Ribble Valley Borough Council
Council Offices
Church Walk,
Clitheroe
Lancashire
BB7 2RA

Phone: 0300 123 6780
Email: Kathryn.Walsh@lancashire.gov.uk
Your ref: 3/2024/0745
Our ref: 3/2024/0745/HDC/KW
Date: 23 October 2024

Location: Avenue Farm Avenue Road Hurst Green BB7 9QB
Proposal: Proposed demolition of existing dwelling, erection of replacement two-storey, four bedroom self-build dwelling with detached double garage and associated site works.
Grid Ref: 368275 438410

Proposed Garage Plan

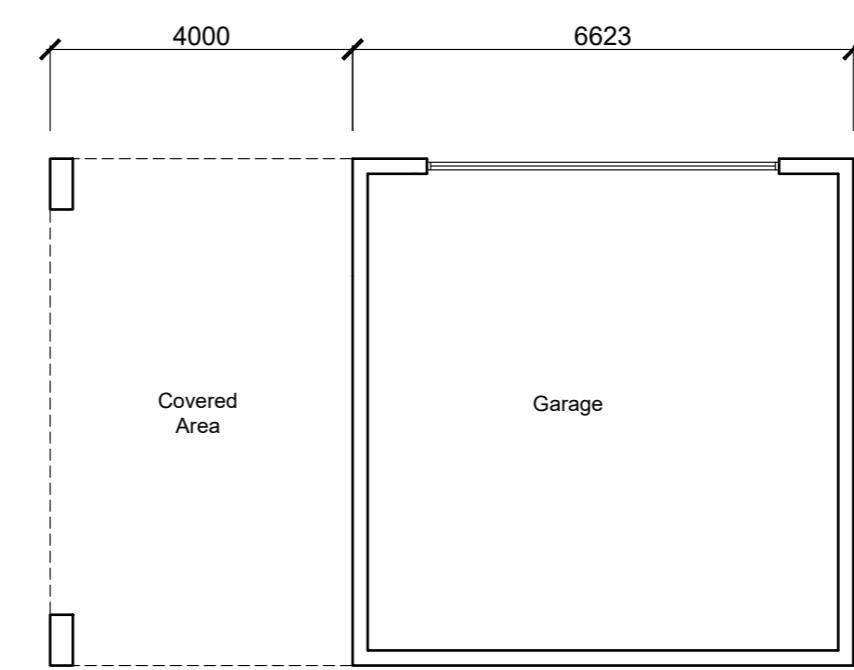
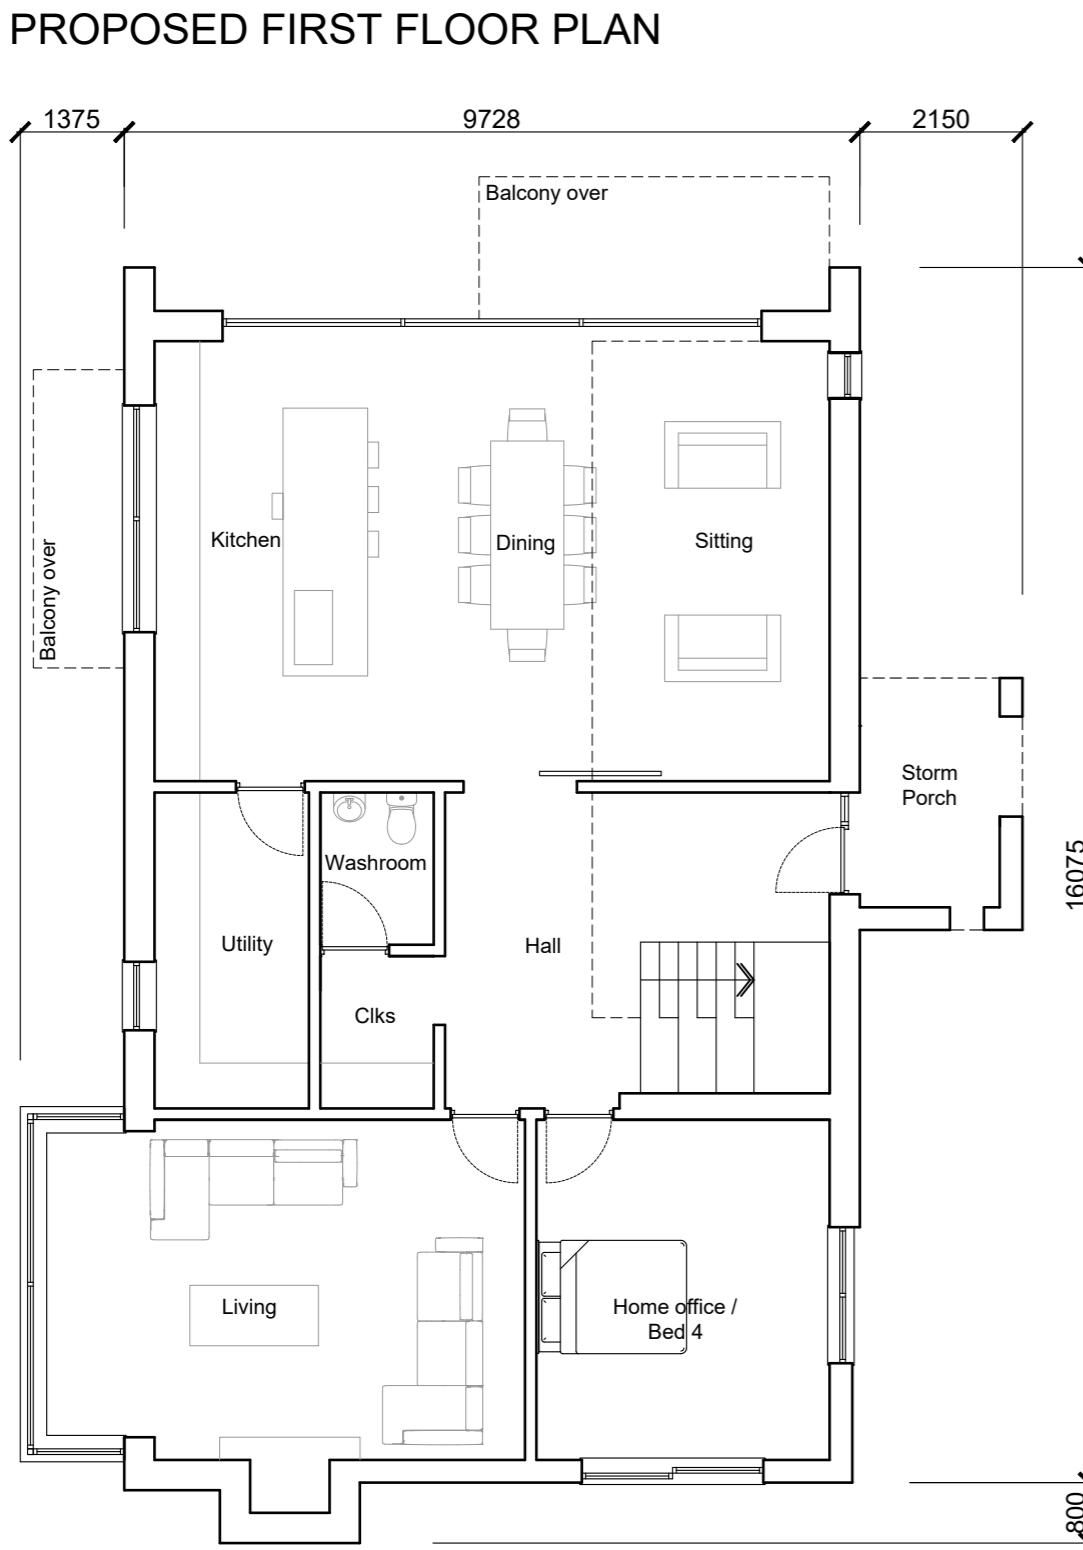
The LHA has also reviewed the proposed floor plan drawing 24-016 PL06, and the LHA note that the proposed dwelling complies with the LHAs parking standards as defined in the Joint Lancashire Structure Plan.

The recommended minimum internal dimensions for a double garage size is 6m in length and 6m wide. The recommended distance of 6m is based on the length of a large family car (Ford Mondeo Estate 4.58m long), clearance at the rear of the car (200mm), overhang of the garage door (600mm) and room to stand in front of the car and open/close the garage door (600mm). As the garage meets the minimum internal dimension of 6 x 6m it will be counted as a parking space. Due to its size secure cover cycle storage can also be provided within the garage.

6. The garage hereby approved shall be kept available for the parking of vehicles ancillary to the enjoyment of the household and shall not be used for any use that would preclude the ability of their use for the parking of private motor vehicles, whether or not permitted by the provisions of the Town and Country Planning (General Permitted Development) Order 2015 or any order amending or revoking and re-enacting that order.
